El Paso County Master Plan - Draft Plan Questionnaire

This questionnaire is for you to provide feedback about the draft *Your El Paso Master Plan*. After review of the draft Plan and StoryMap, please identify any changes you would make to the document. For each change, please be sure to include the specific page number from the draft Plan. This will help us connect your comment to the correct section.

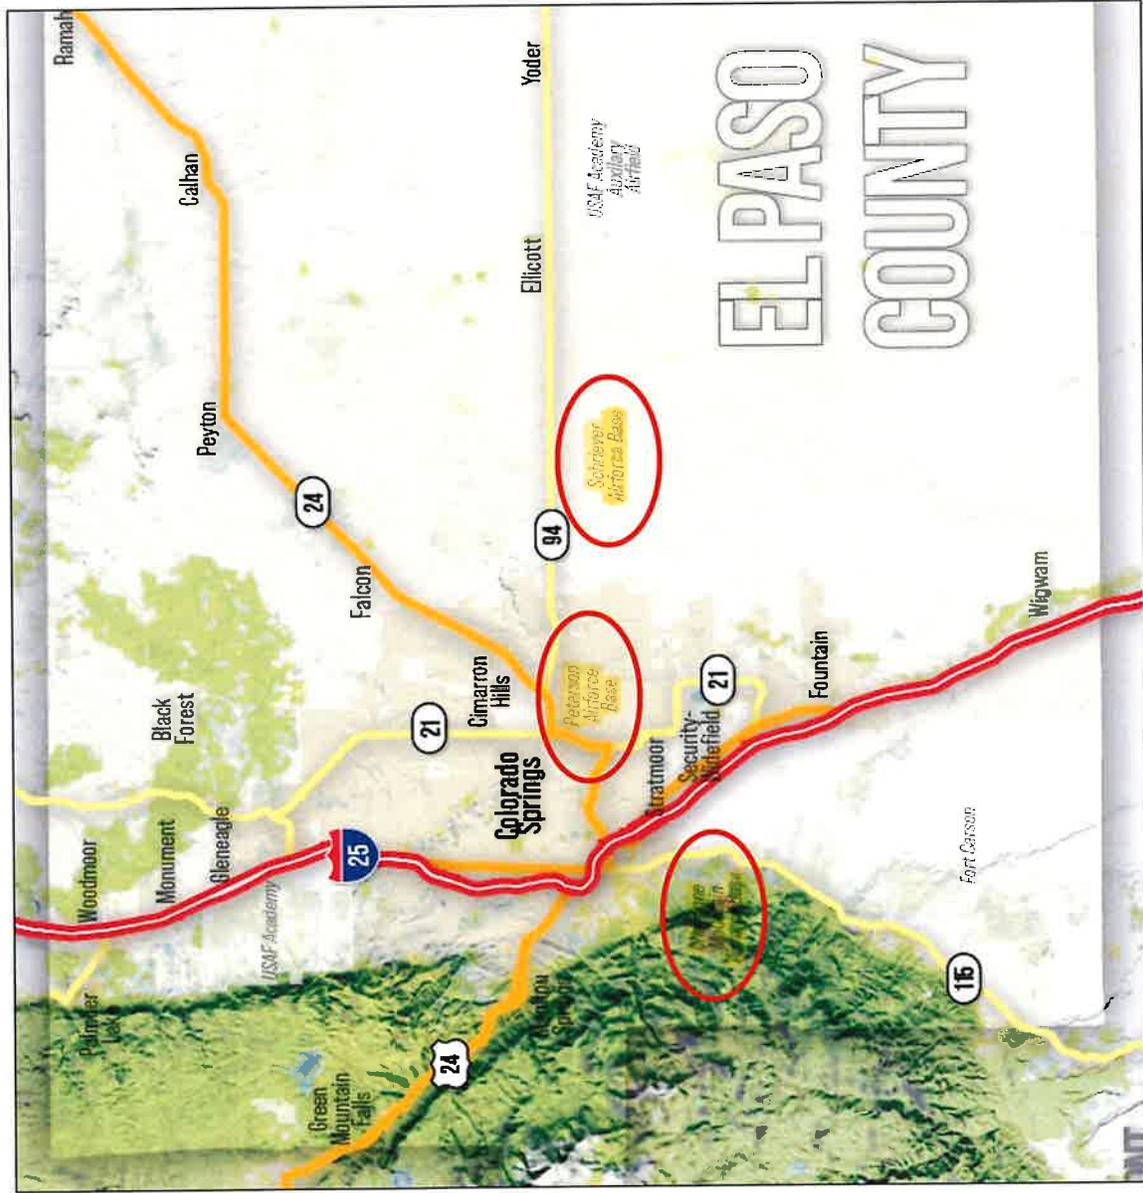
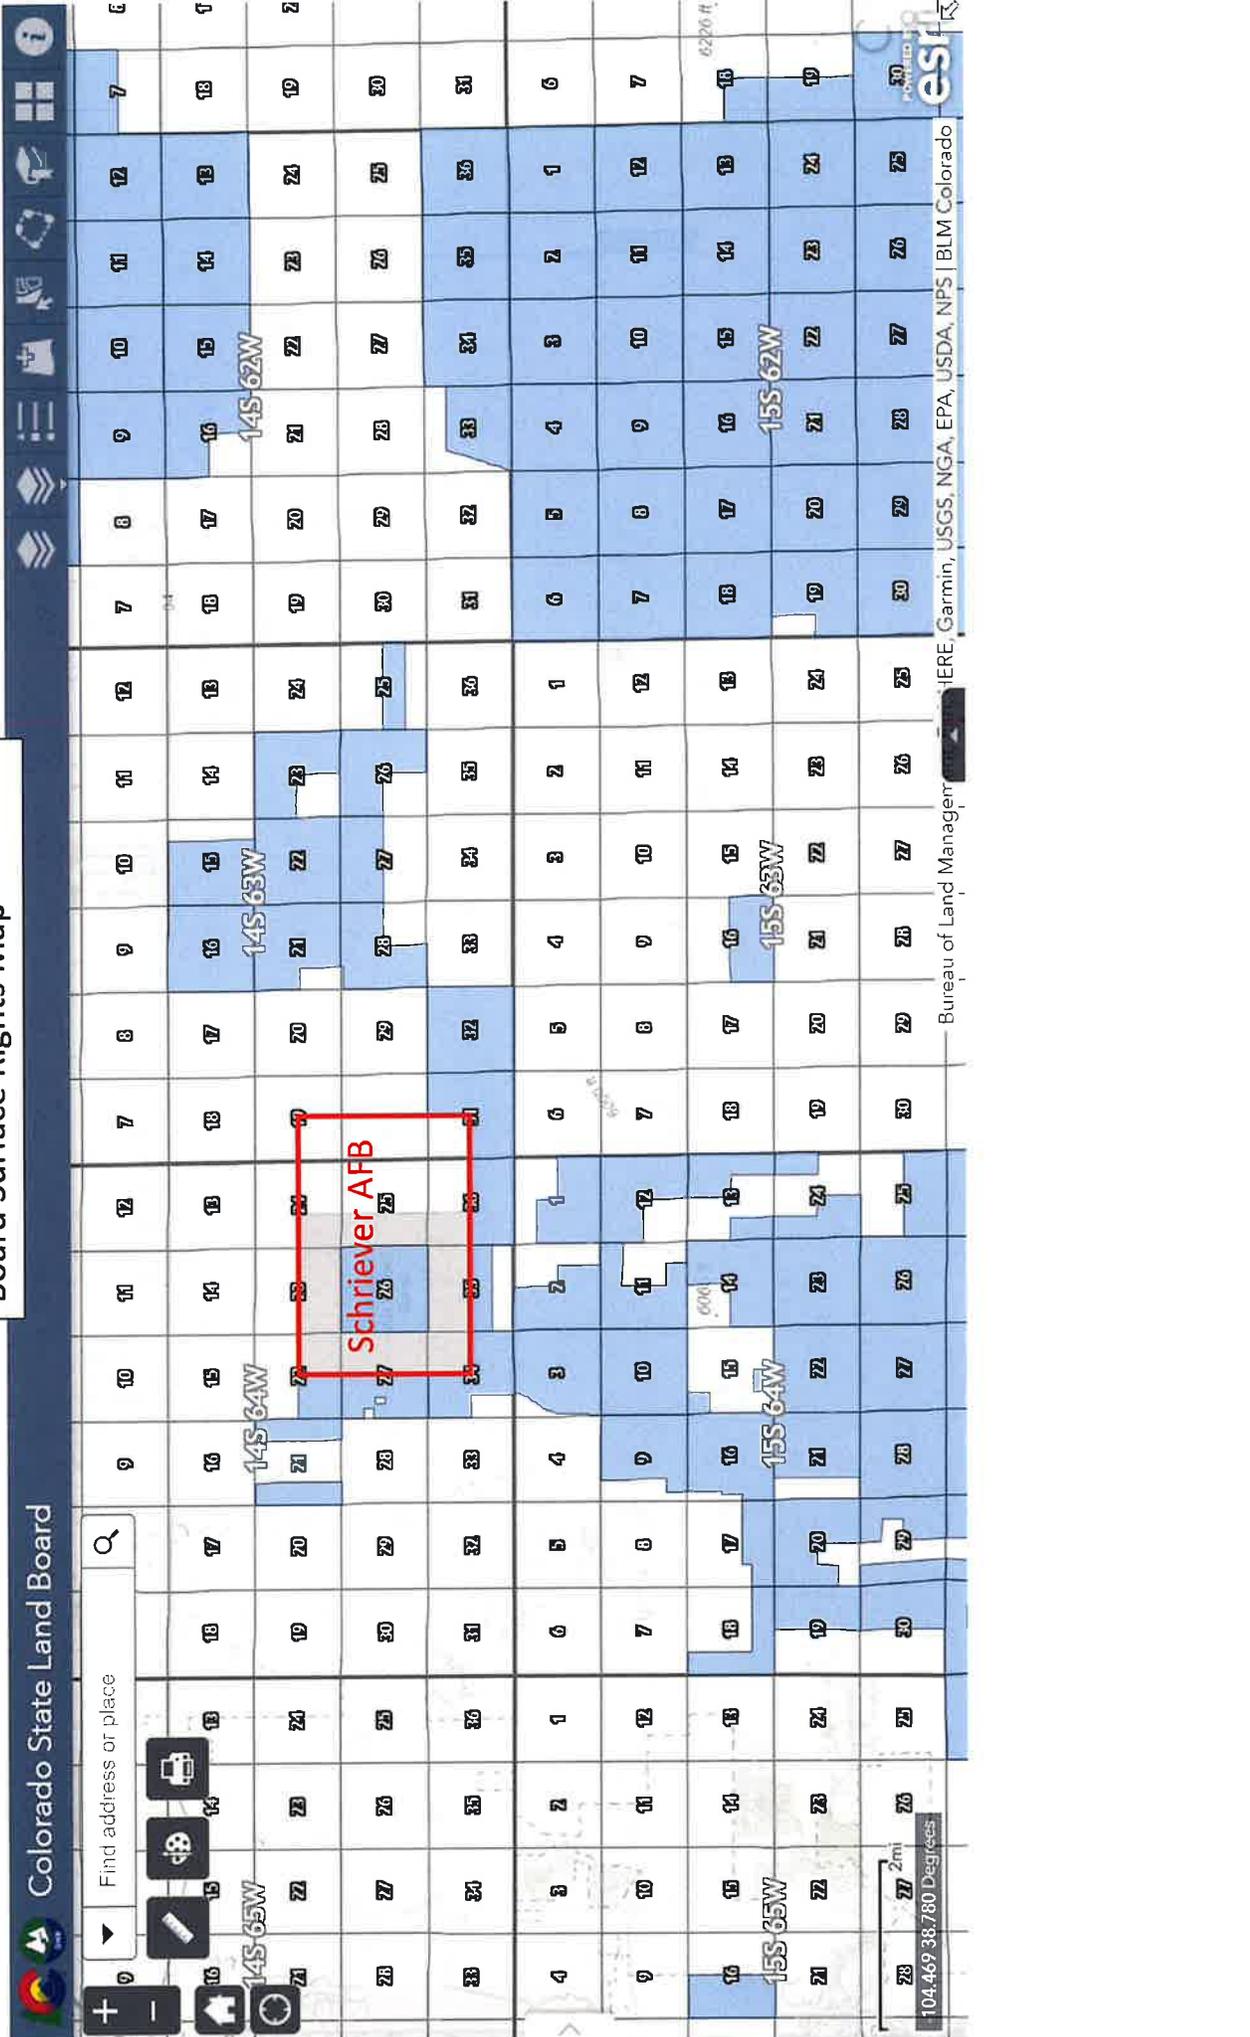
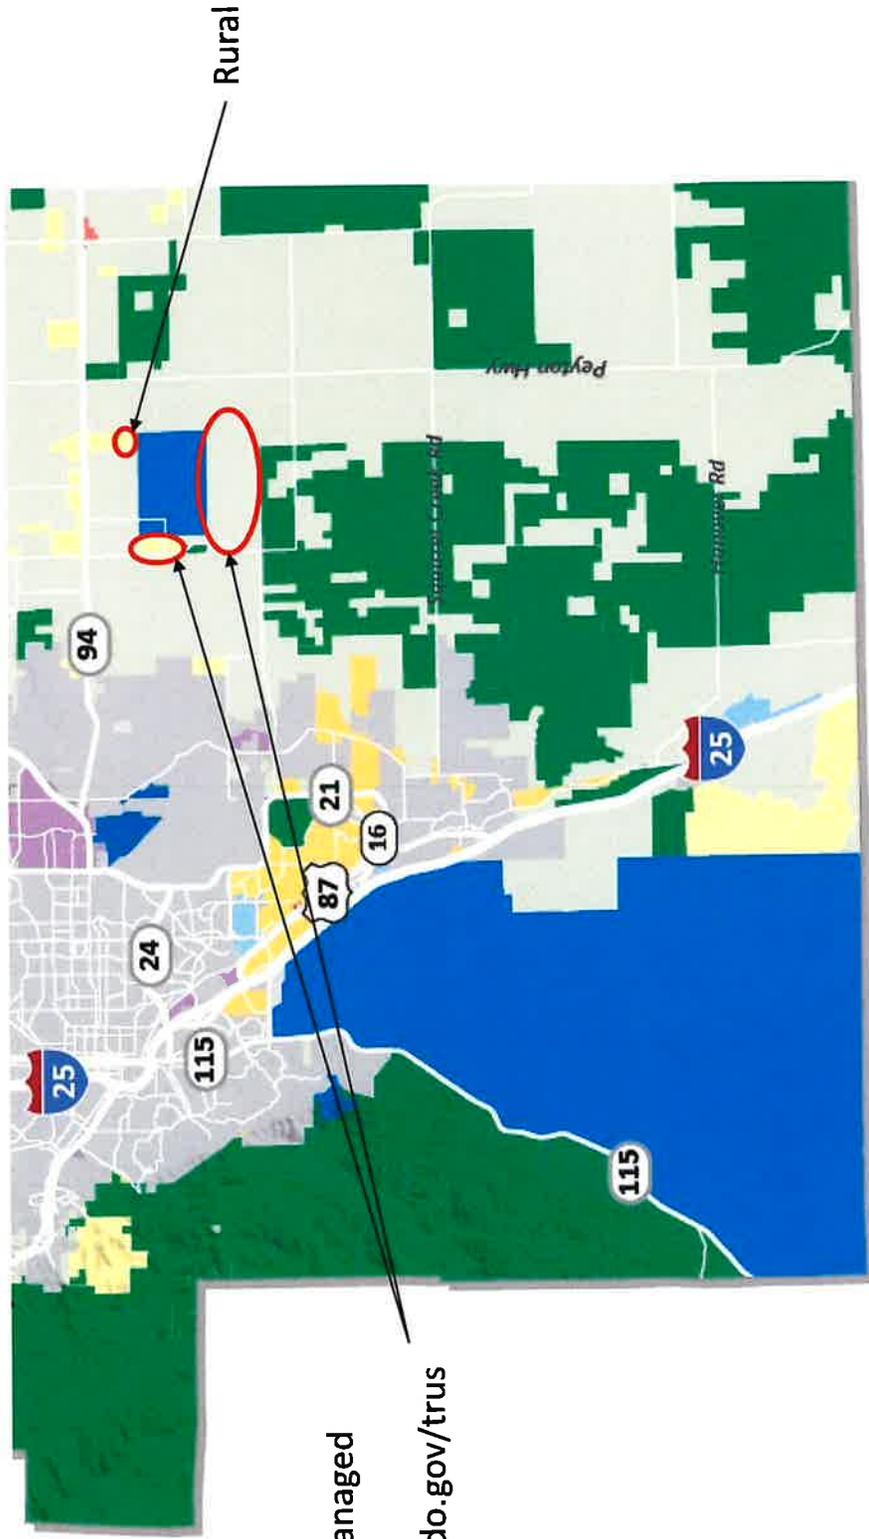
Pg 6, Map: Change Airforce Base to Air Force Base for Schriever & Peterson. Cheyenne Mountain is an Air Force Station. Change labels for other plan maps (17, 20, 22, 49, 50, 64, 67, 74, 75, 127).

Existing Land Use

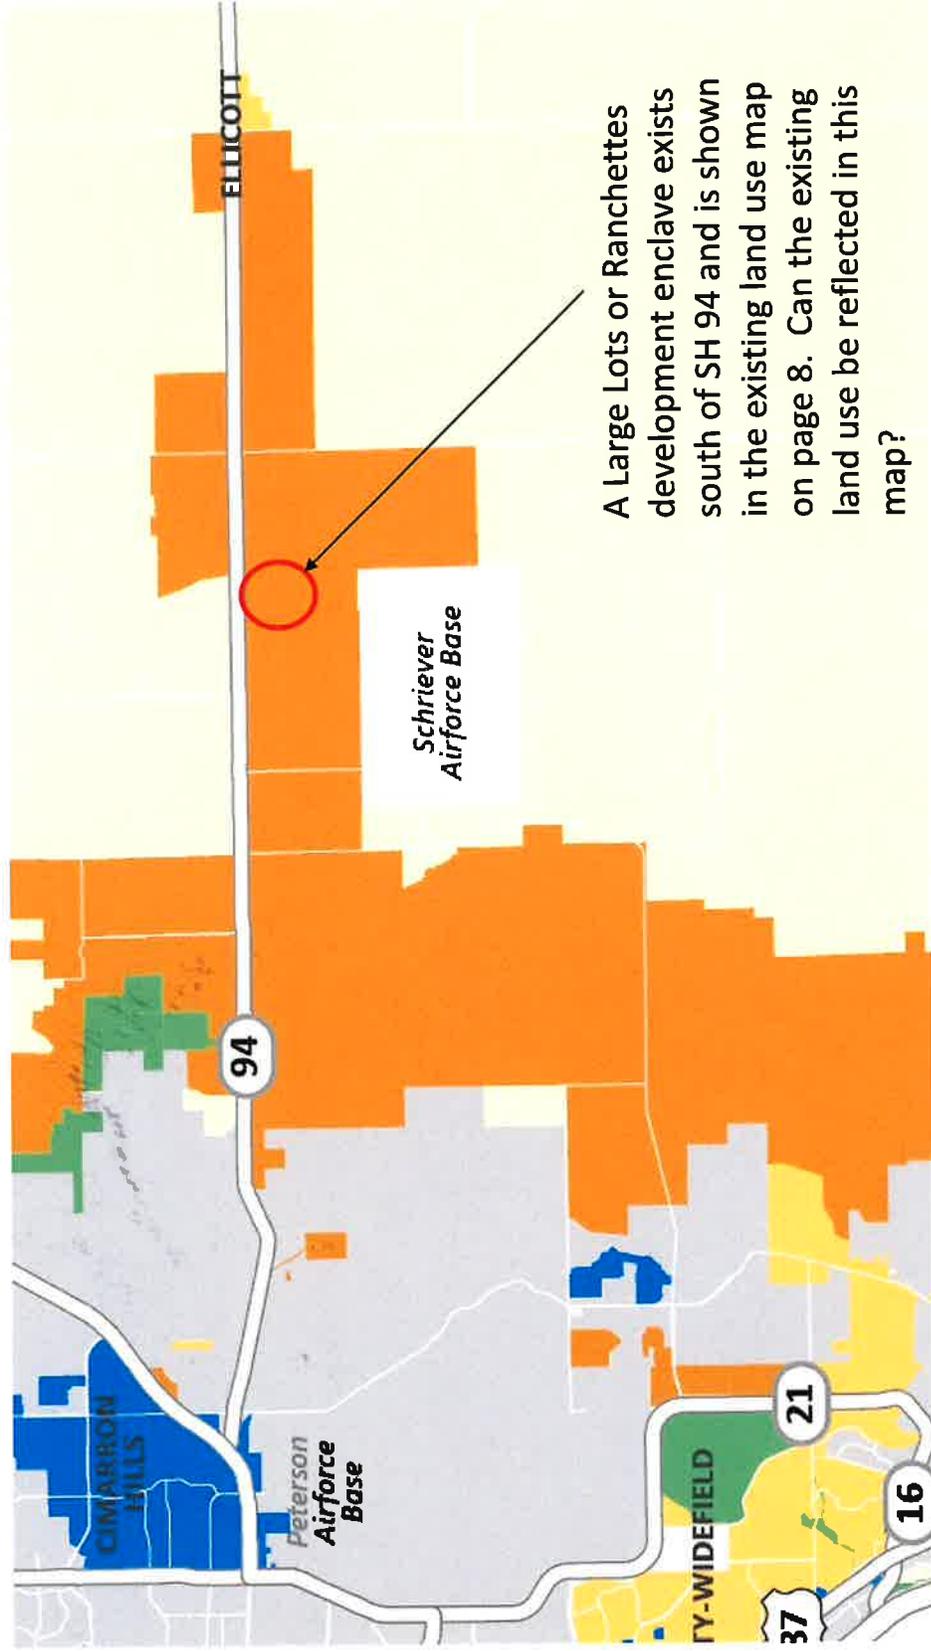
Pg 8, Map: See <https://gis.colorado.gov/trustlands/> map for managed lands near Schriever AFB. Large Lots or Ranchettes incorrectly shown adjoining Schriever AFB to the NE (should be ½ mile gap) and West (only two small residential parcels located east of Curtis Road, surrounded by CSLB managed lands).

Page 22 – Placetypes Map

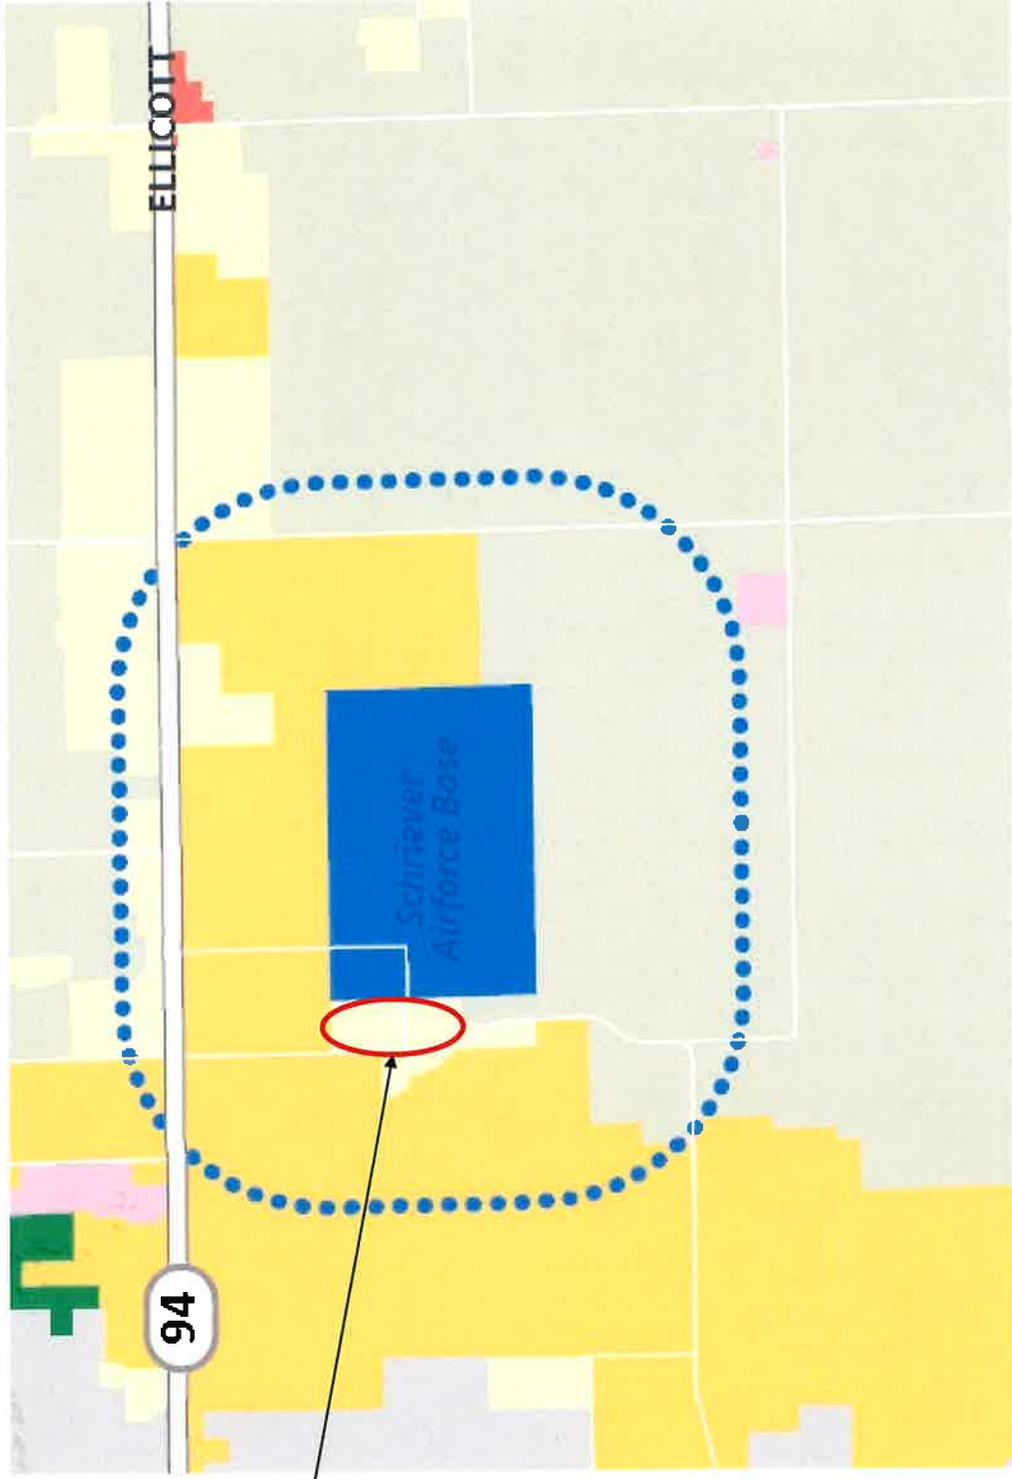
Pg 22, Map: Area west of Schriever AFB to Curtis Road almost all Rural, not Large-Lot Residential.

**Page 24 – Rural
Placetype Map**

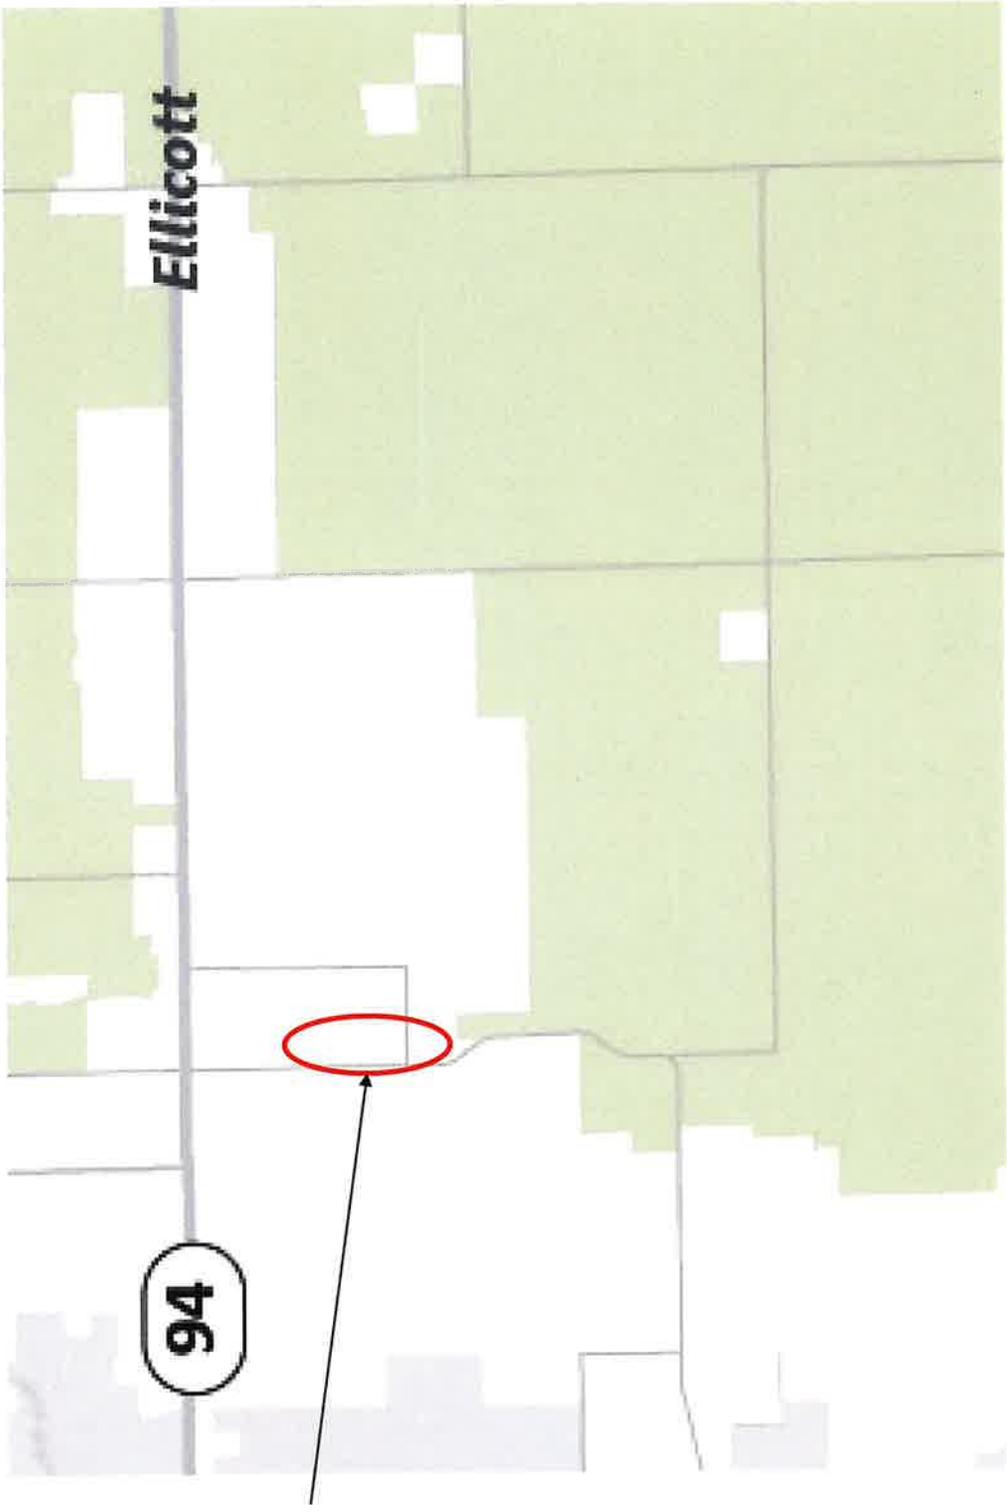
Pg 24, Map: See Pg 22 comment.

**Page 26 – Large-Lot
Residential Placetype
Map**

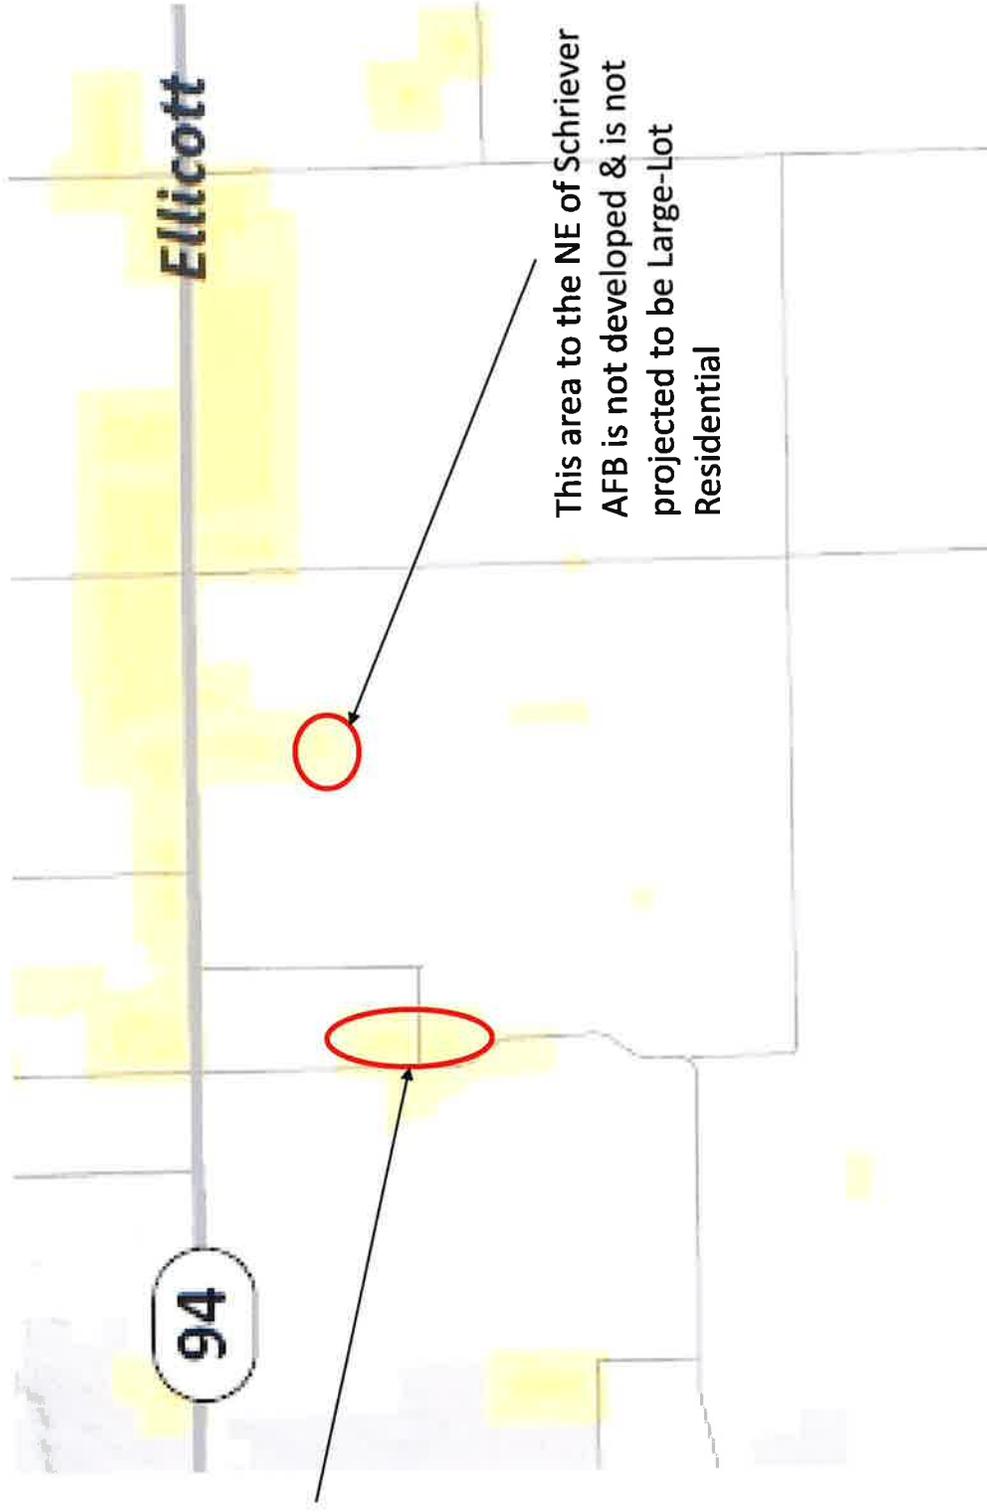
Pg 26, Map: See Pg 22 comment and Pg 8 comment in Ch. 1.
